Tuesday, 17 May 2016

Development Manager, Darling Square
Level 5, 405-411 Sussex Street, Sydney, NSW 2000 Australia

RE: RESPONSE TO DEPARTMENT OF PLANNING & ENVIRONMENT (DPE) COMMENTS

Figure 8: Pedestrian wind speed measurement locations with comfort/distress ratings – Ground Level

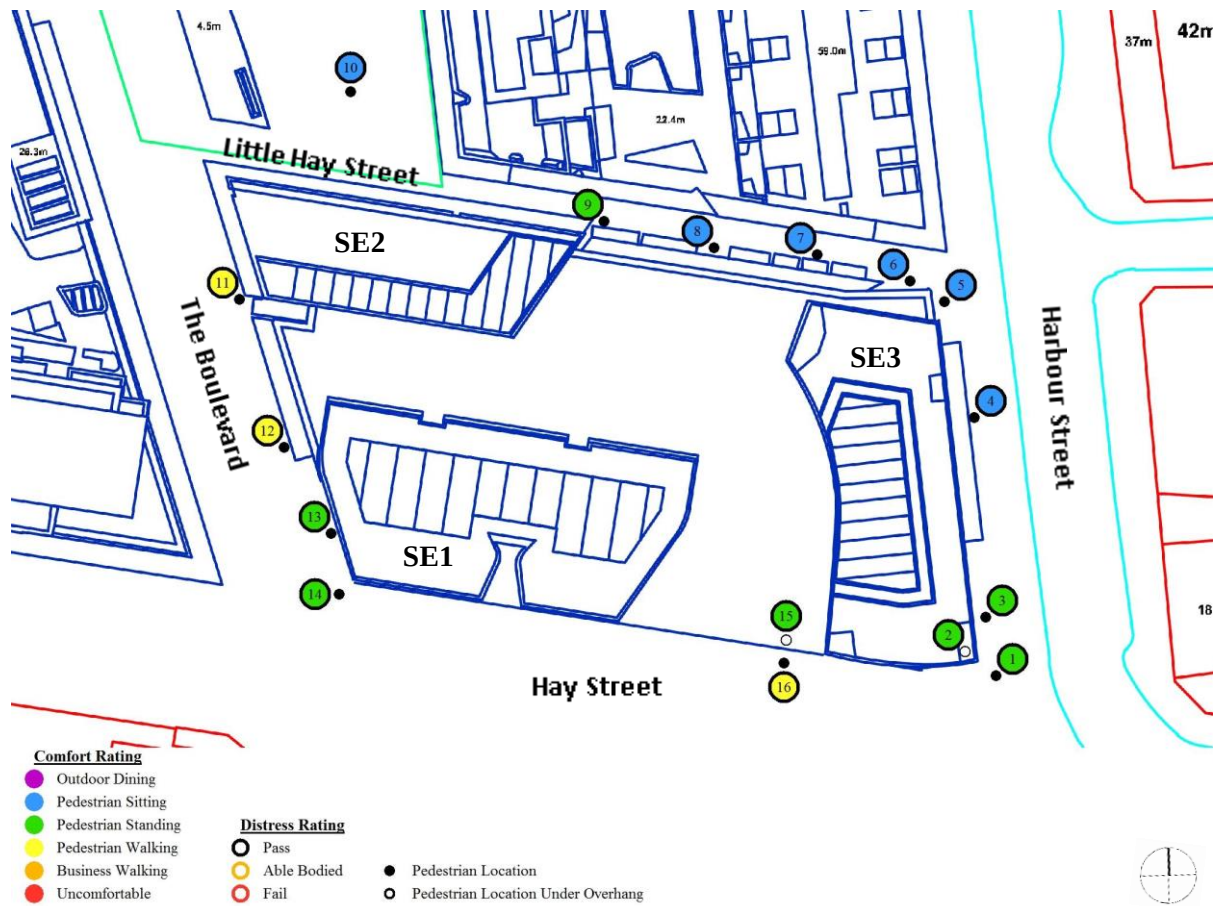
7. Justify the use of planting to screen the blank wall of the above ground car park.

- a) Provide information on the likely success of the planting in this location and how long it will take for the planting to provide an effective screen

Based on the project wind report by CCP (Project 8253, February 2016) the north façade, location 6,7,8 within the report, passed the distress criterion and are deemed suitable for pedestrian sitting activities. Such assessment suggests that the north façade will be relatively protected and will not suffer from extreme wind events. Additionally, the planting area location sits inside the outer building façade further protected from wind tunnel shearing effects.
